69 Nyewood Lane Bognor Regis PO21 2SD

Vehicle crossover & creation of gravel topped hardstanding.

TO:	Arun District Council FAO: Pat Aird
FROM:	Highways, WSCC
DATE:	26/06/2018
LOCATION:	69, Nyewood Lane, Bognor Regis, West Sussex, PO21 2SD
SUBJECT:	BR/122/18/HH Vehicle crossover & creation of gravel topped hardstanding.
DATE OF SITE VISIT:	N/A
RECOMMENDATION:	☒ Advice ☐ Objection ☐ Modification ☐ No Objection ☐ More Information ☐ Refusal
S106 CONTRIBUTION TOTAL:	£N/A See below for breakdown.

Block Plan shows area bounded by: 492633.0, 89032.98 492669.0, 89068.98 (at a scale of 1:200). OSGridRef: SZ92659905. The representation of a road, track or path is no evidence of a right of way. The representation of features as lines is no evidence of a property boundary.

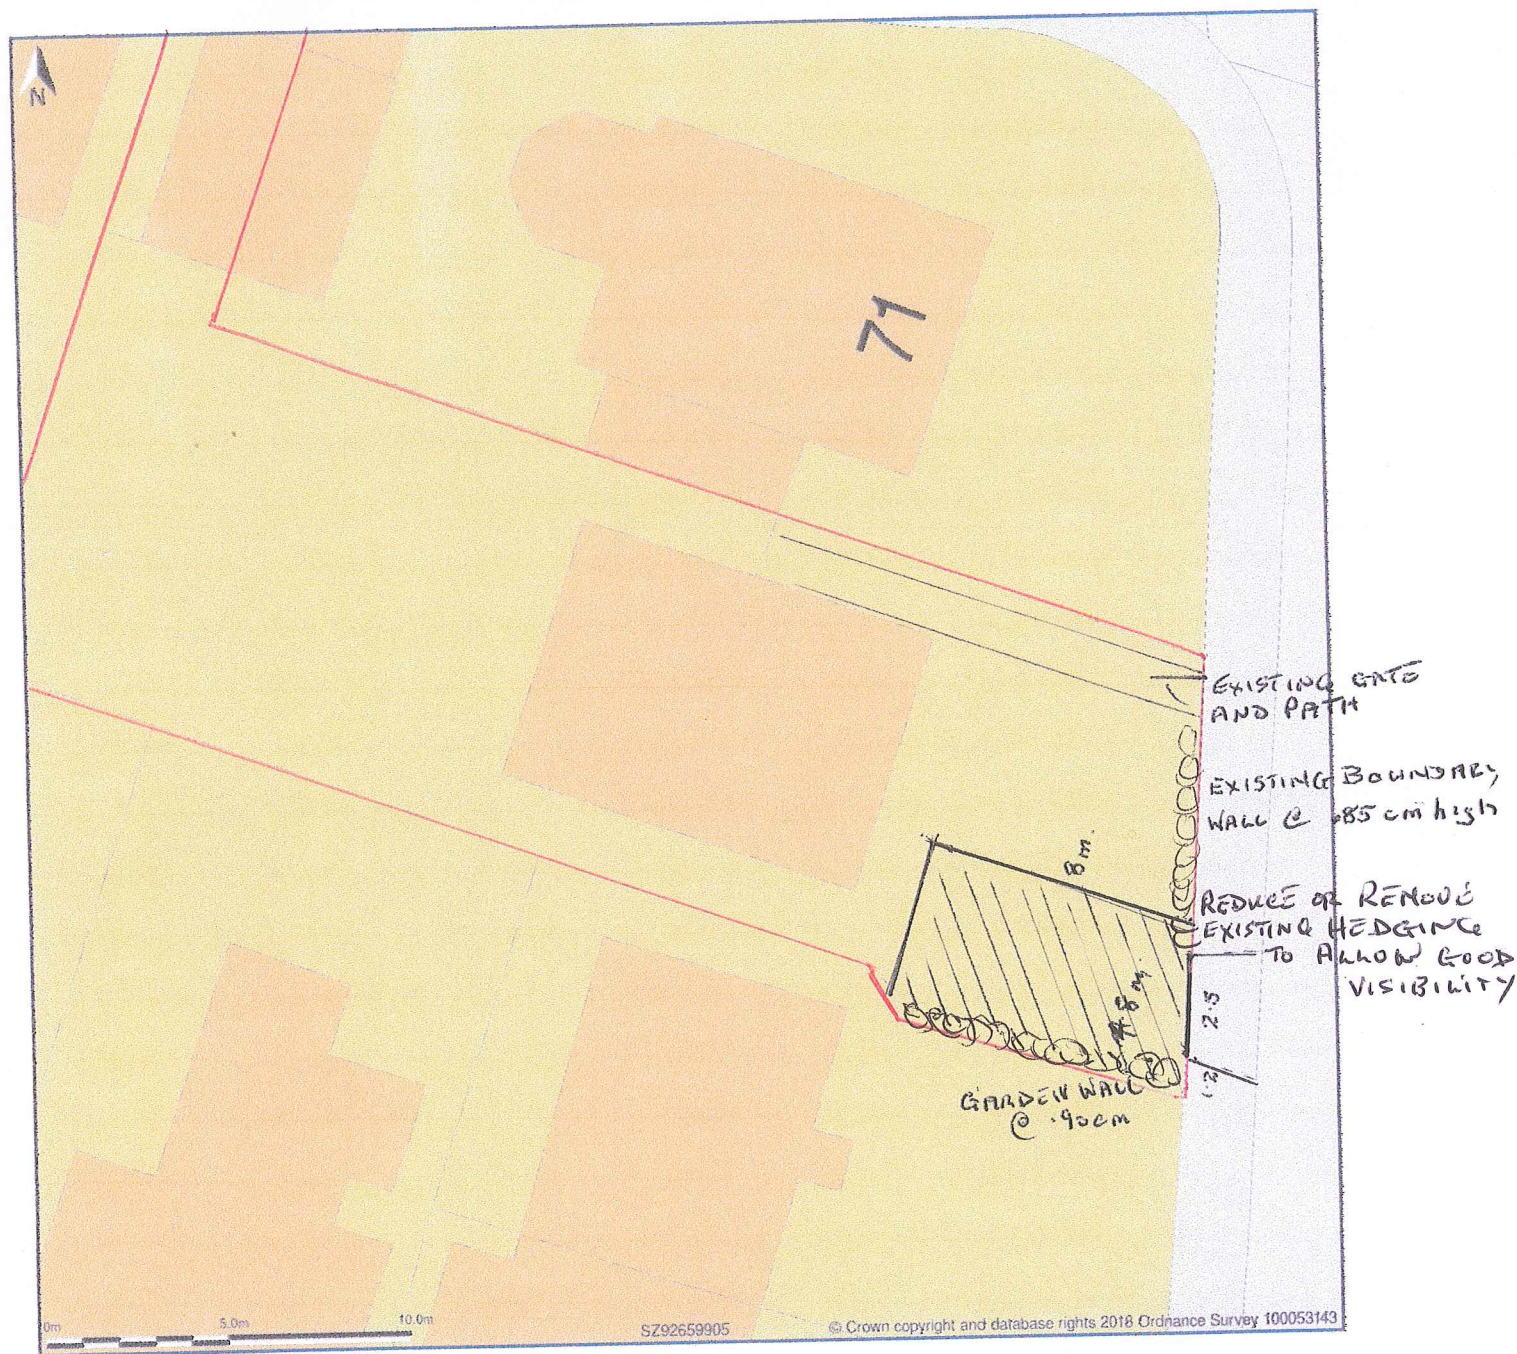
The site does not currently benefit from a vehicular crossover or off-street parking. The proposed VCO is approximately 3m wide at the kerb edge. A licence would be required for the proposed VCO and must be constructed to a specification agreed with the Local Highways Engineer.

The applicant has not provided vehicular visibility splays for the proposed access. Nyewood Lane is subject to 30mph, and due to the presence of on-street parking, vehicles are not anticipated to be exceeding the posted speed limit within the vicinity. As such, the LHA would expect that vehicular visibility at a 2m X distance at this site is sufficient for the anticipated road speeds. Furthermore, an inspection of data supplied to WSCC by Sussex Police over a period of the last five years reveals that there have been no recorded injury accidents within the vicinity of the site and there is no evidence to suggest that a VCO in this location would exacerbate an existing safety concern.

Considering the footway traffic along Nyewood Lane, there would be a benefit for the applicant to provide pedestrian visibility splays. Pedestrian visibility splays should be taken 2m back into the access and a distance measured along the back of the footway for 2m on each side of the access. There should be no obstructions over 0.6m within these splays. The site appears to have sufficient space along the east boundary to provide a pedestrian visibility splay of 2 x 2m to the north of the proposed access. The LHA note that to the south of the proposed access, there is insufficient space to accommodate the desired pedestrian visibility splay, however the LHA acknowledge that the garden wall to the south boundary is currently 0.9m in height and would advise that this is reduced to a maximum height of 0.6m for the first 2m back into the site. This is to allow pedestrian visibility

The application form indicates that one parking space is proposed for the dwelling. Manual for Streets sets out minimum specifications per parking space of 2.4 x 4.8m. The proposed plans indicate that the parking area will be 4 x 8m (excluding the proposed landscaped area to the south of the parking area).

A turn on site would be preferred although clearly there is insufficient space to accommodate this. However other properties have similar arrangements and balanced against this is the benefit of providing an opportunity to remove a vehicle that would otherwise be parked on the highway in a location where the existing practice is on-street parking by residents of adjoining properties which results in a noticeable narrowing of the existing available carriageway space.

No part of the development shall be first occupied until pedestrian visibility splays have been provided either side of the proposed site vehicular access onto Nyewood Lane in accordance with plans and details to be submitted to and approved in writing by the Local Planning Authority. These visibility splays shall thereafter be kept free of all obstructions over a height of 0.6 metre above adjoining carriageway level or as otherwise agreed.

No part of the development shall be first occupied until the car parking has been constructed in accordance with the approved site plan. These spaces shall thereafter be retained at all times for their designated purpose.
